**Consultation Response from KC,
Highways Development Management**

2024/92978 Land adjacent to, 152, Somerset Road, Almondbury, Huddersfield, HD5 8HY

**Discharge of details reserved by Conditions 7 & 8 (materials) 10 (access) of permission
2023/91327 for Erection of detached dwelling**

Site Plan
1 : 200

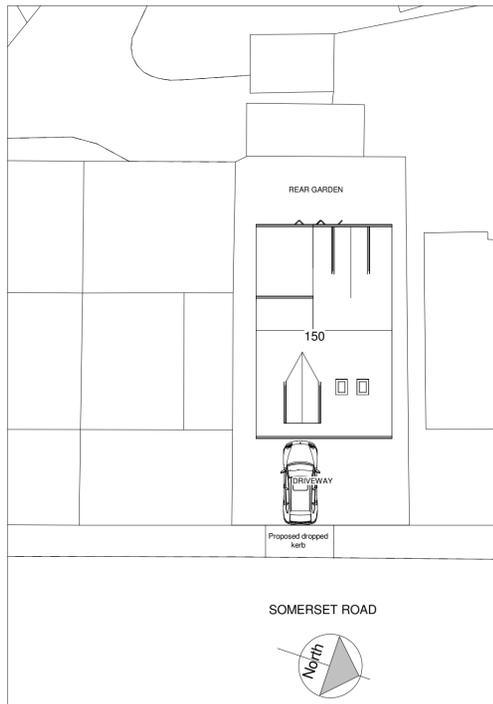
The applicants have provided plan drawing number 772-001 rev G showing the proposed site access and the disabled parking space previously blocking this access has now been moved away from the front of the site.

Highways Development Management have therefore no objection to the discharge of this condition.
